Roads and Maritime Reference: SYD18/02001 (A29917894)

Department Reference: SSD-9809

CONSTRUCTION OF MARSDEN PARK PUBLIC SCHOOL (SSD-9809)

Figure 3-1 - Marsden Park New Primary School Site Development Plan

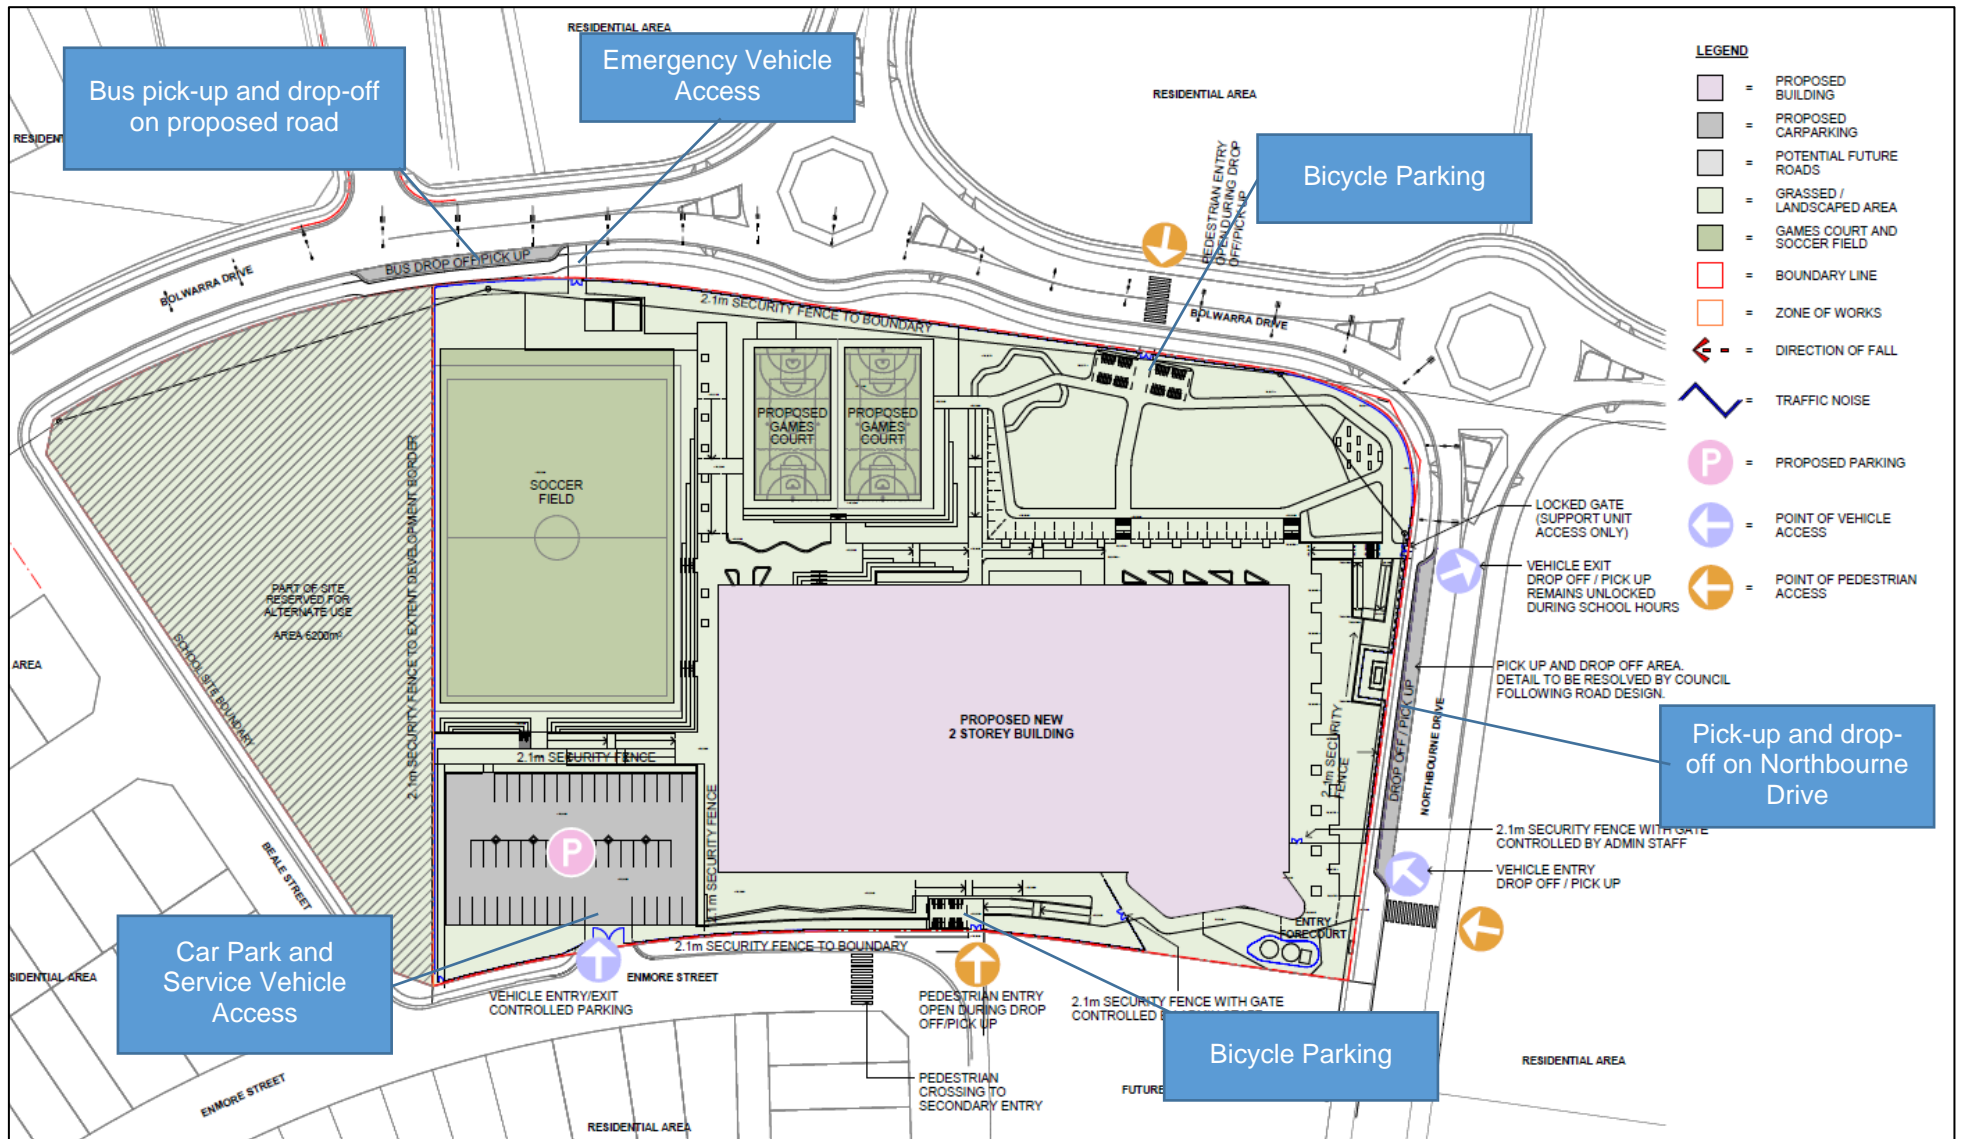
2. The layout of the proposed car parking areas associated with the subject development (including, driveways, grades, turn paths, sight distance requirements in relation to landscaping and/or fencing, aisle widths, aisle lengths, and parking bay dimensions) should be in accordance with AS 2890.1- 2004 and AS2890.6-2009. Parking Restrictions may be required to maintain the required sight distances at the driveway.

**Figure 3-2 - Sight Distance Requirement at Access Driveway**

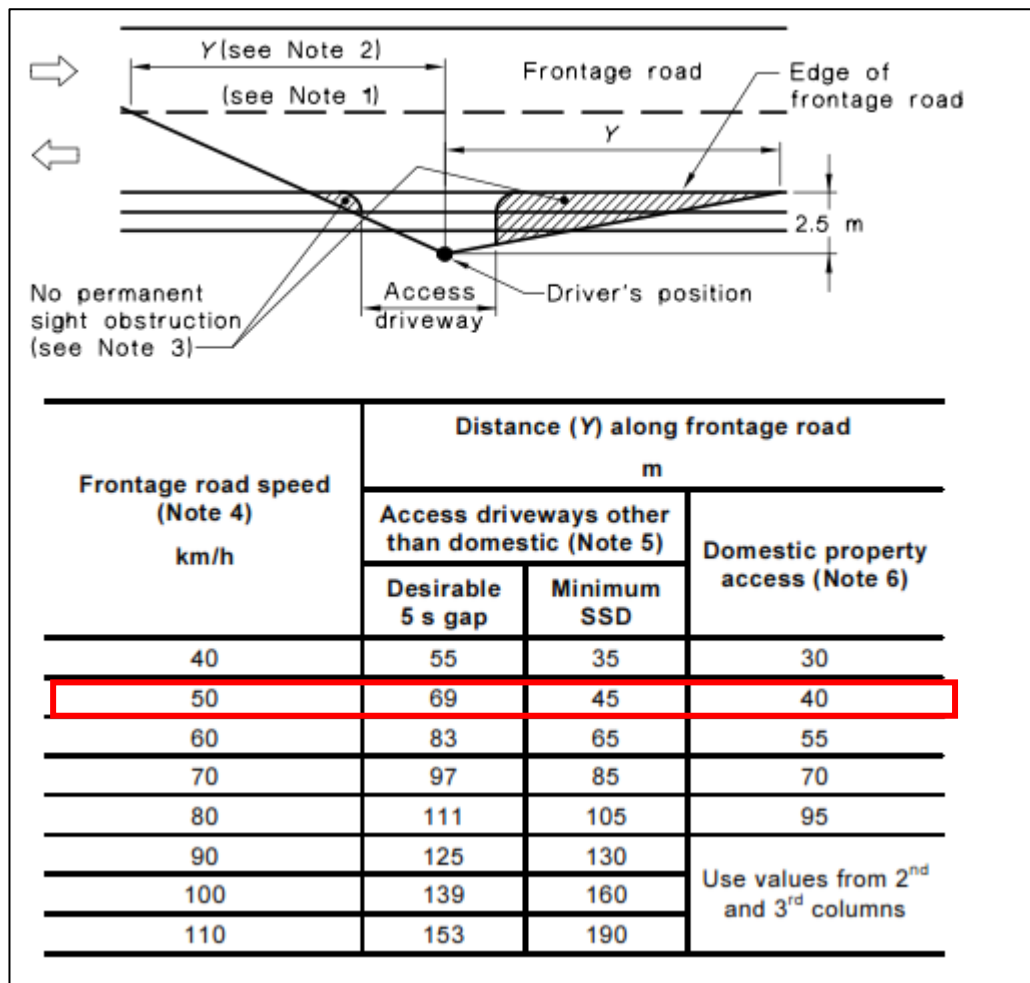
3. Sight distances from the proposed vehicular crossings to vehicles on the proposed local roads are to be in accordance with the Austroads Guide to Road Design: Part 4A: Unsignalised and Signalised Intersections (Section 3 – Sight Distance) and AS 2890. Vegetation and proposed landscaping/fencing must not hinder sight lines to and from the vehicular crossings to motorists, pedestrians and cyclists.
4. All vehicles are to enter and leave the site in a forward direction.
5. The proposed development will generate additional pedestrian movements in the area. Pedestrian safety is to be considered in the vicinity.
